MORNINGTHORPE AND FRITTON PARISH COUNCIL

East Pye Solar – EN0110014***Summary of MFPC Written Statement and Response to OFH2 Action Point*****Status and purpose of this summary**

Figure 11.9:
Public Rights of Way, National Cycle Network
and Bus Stops

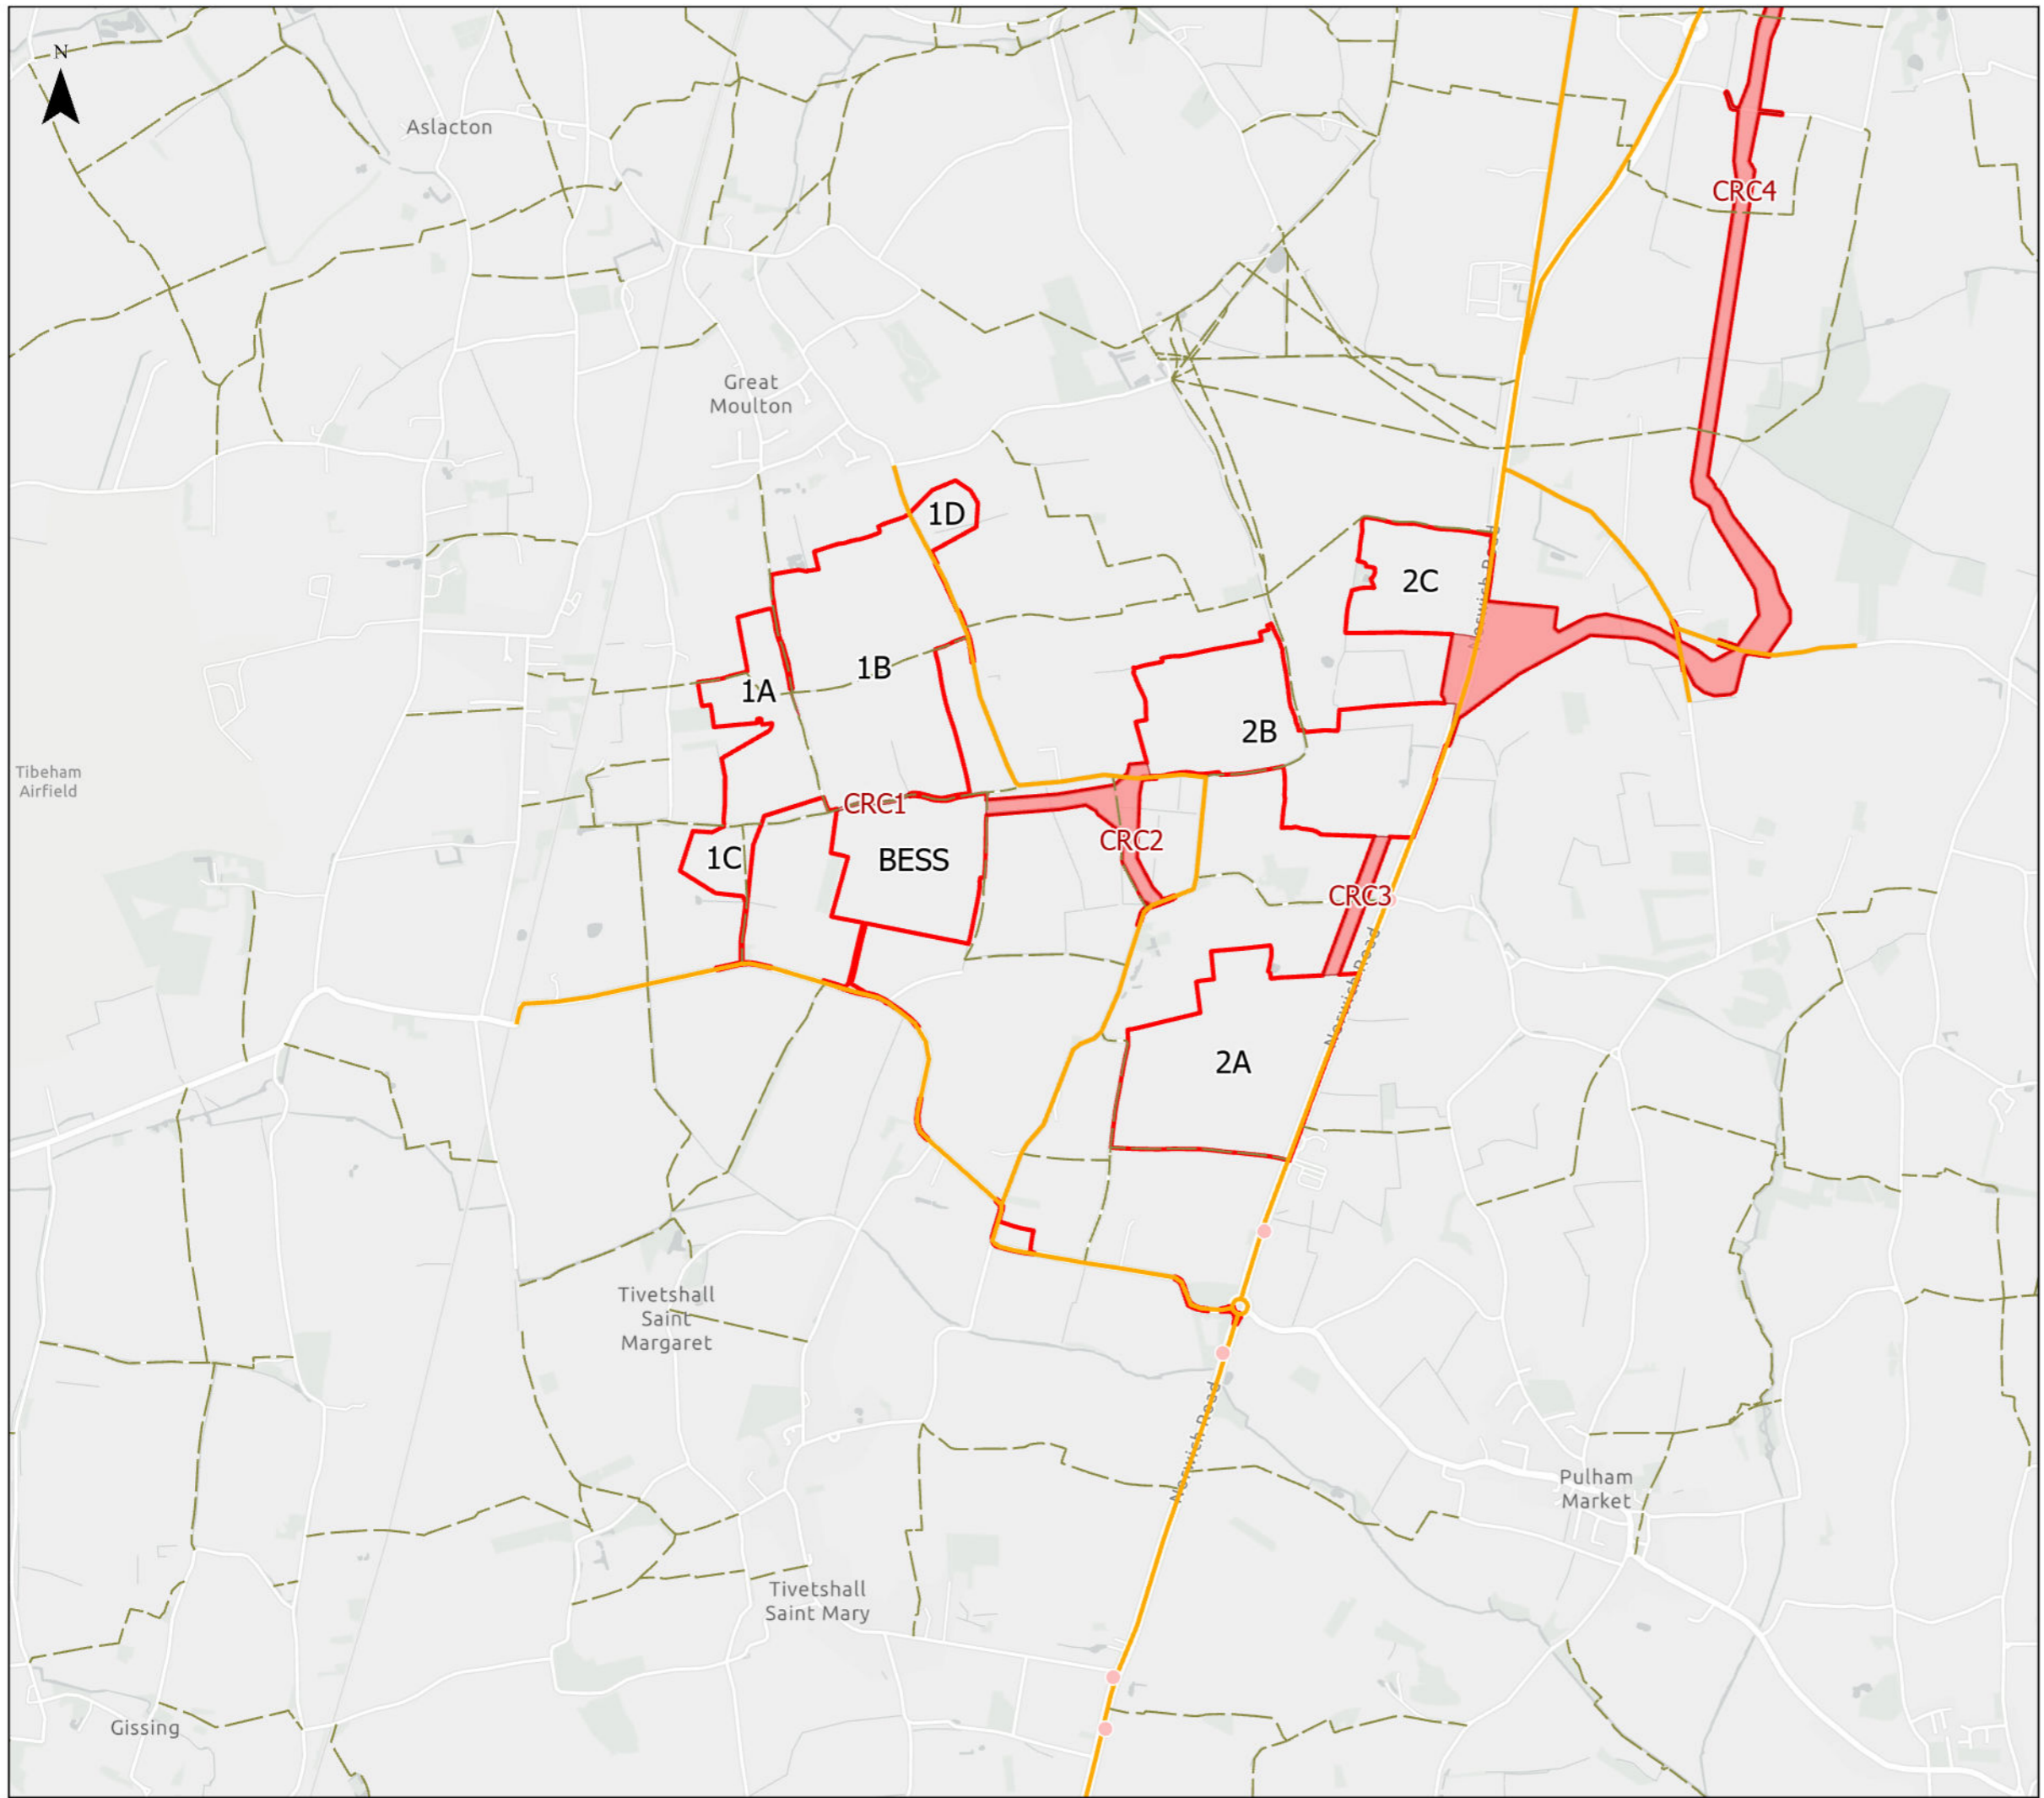
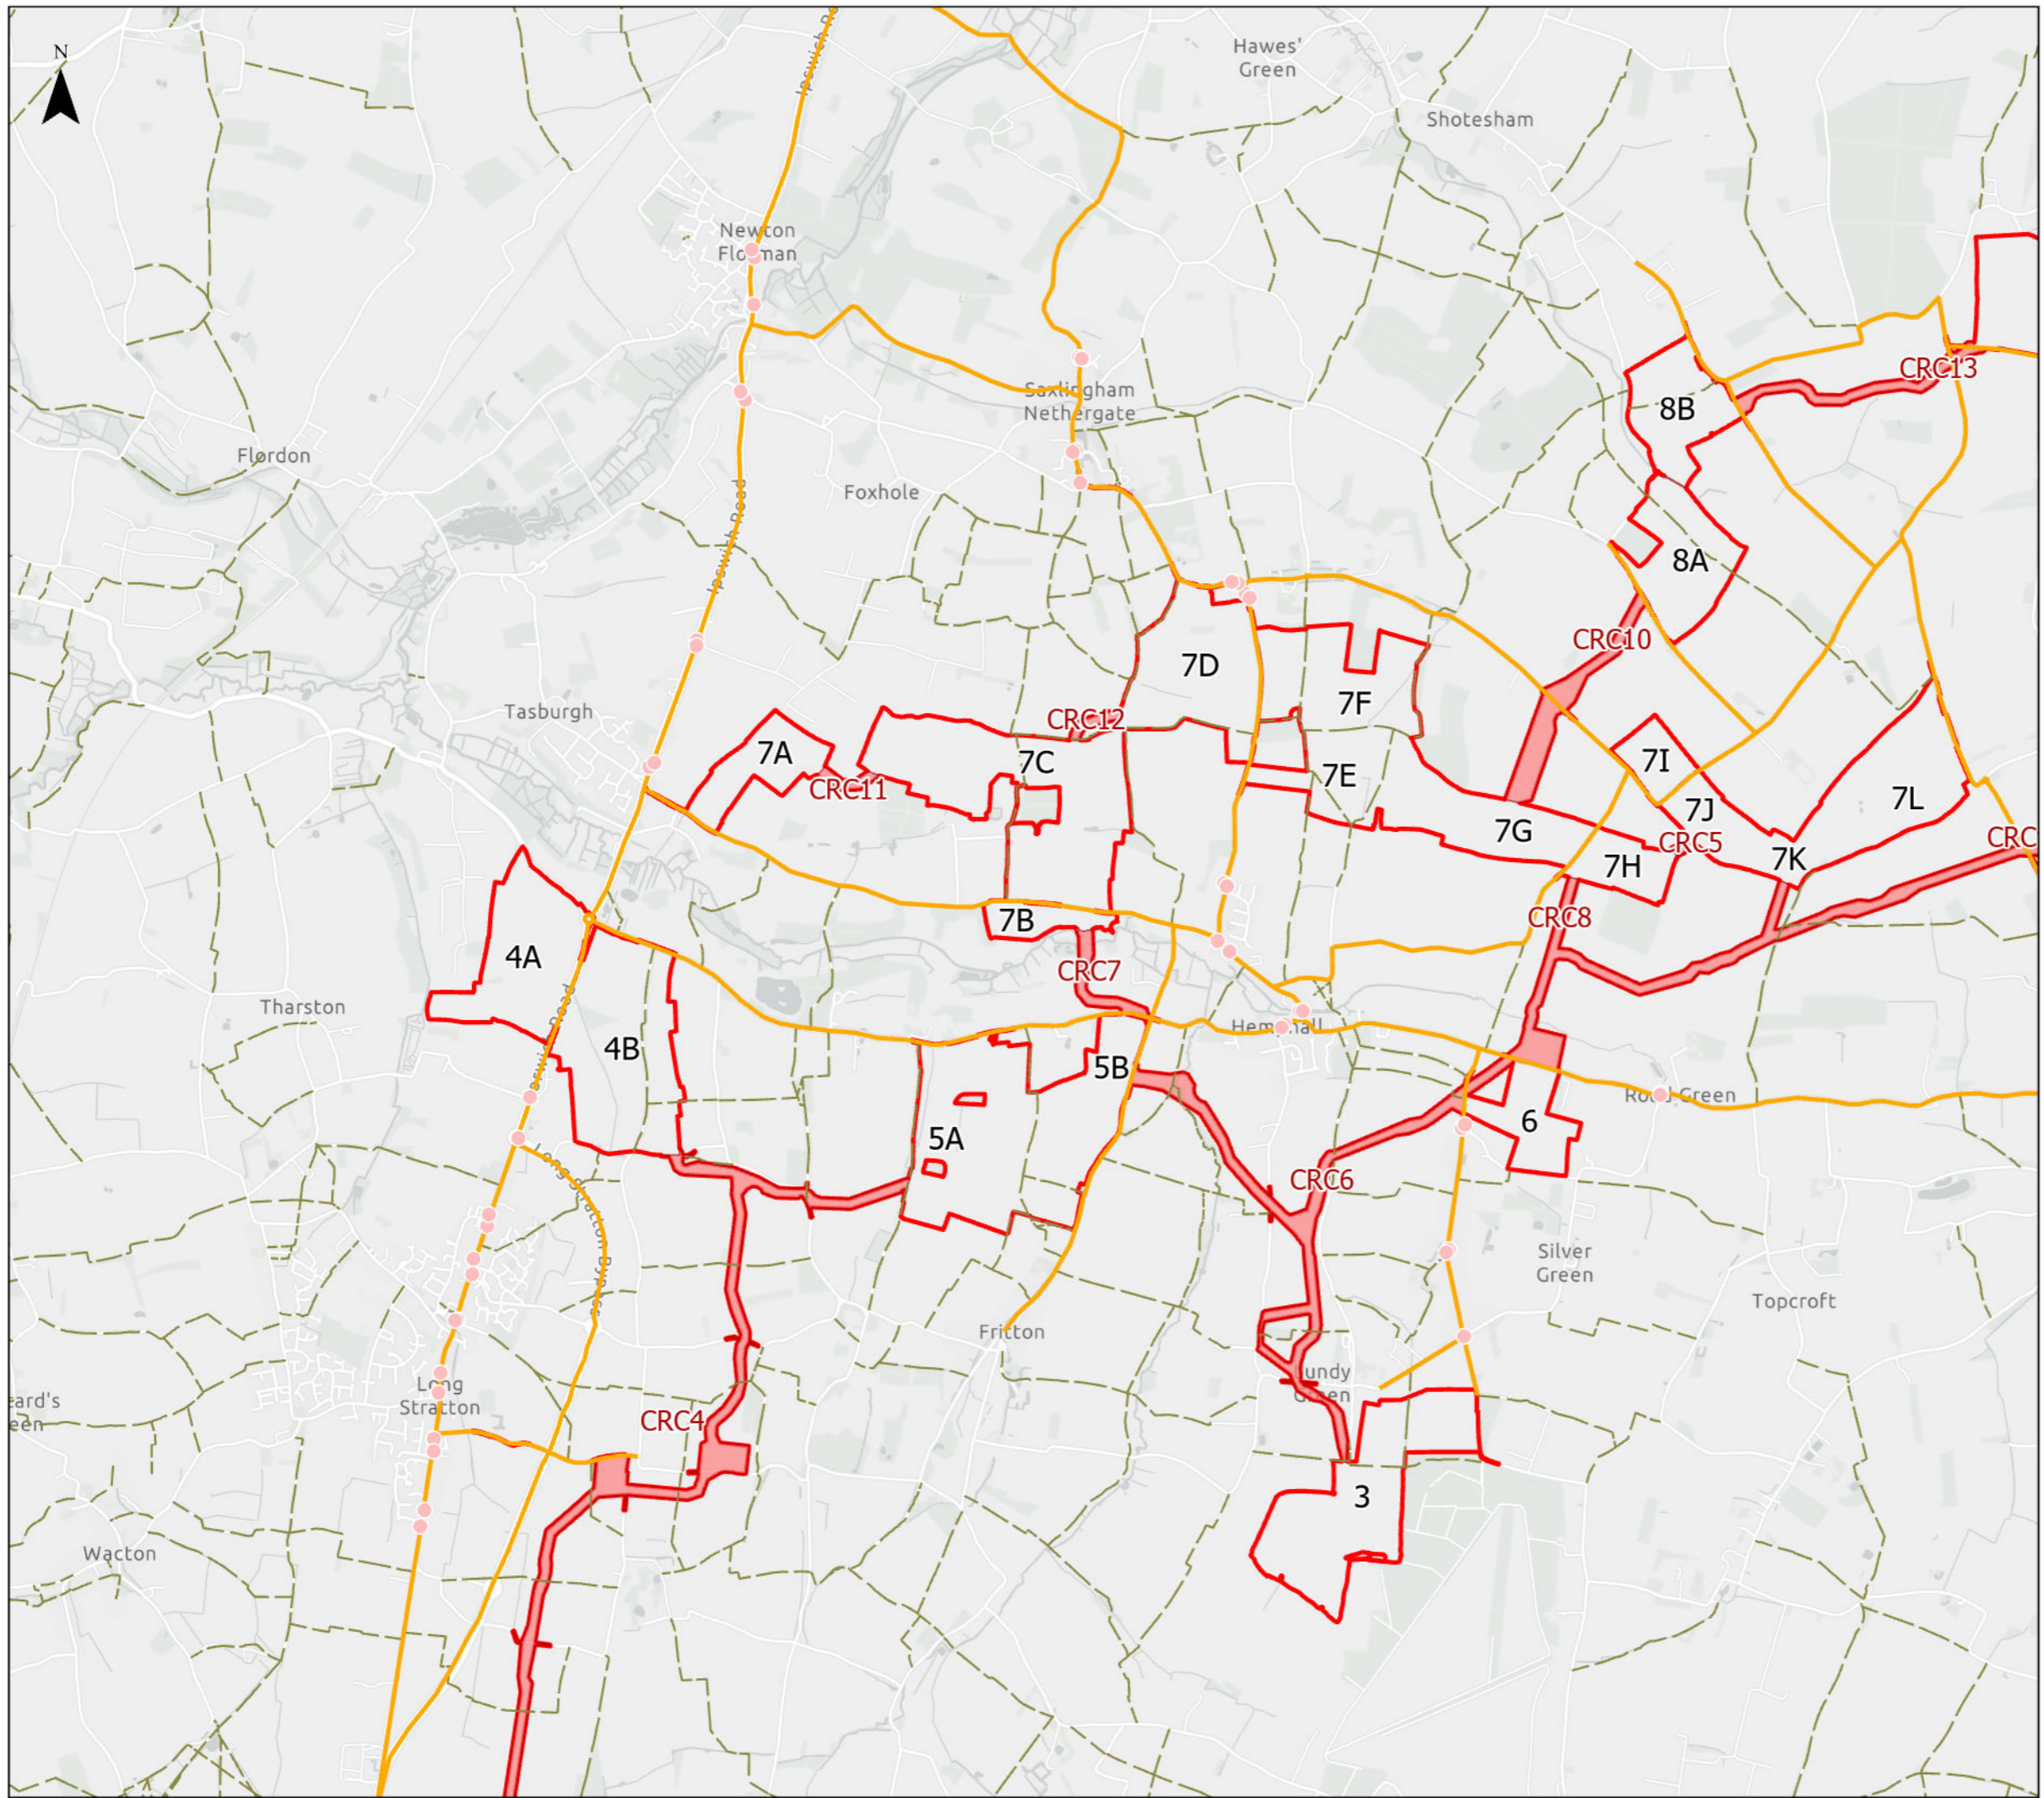
The Public Rights of Way are important to MFPC not simply as transport routes but because of the experience they provide: tranquillity, open views, wildlife, heritage and connection between settlements. Temporary closure or eventual reopening does not by itself preserve that experience. Appendix 1, pp.304–348, documents a footpath journey through and around Site 5 to support this point. Appendix 3, pp.388–396, similarly records the driven experience and views of Site 5 from surrounding roads, including the B1527.
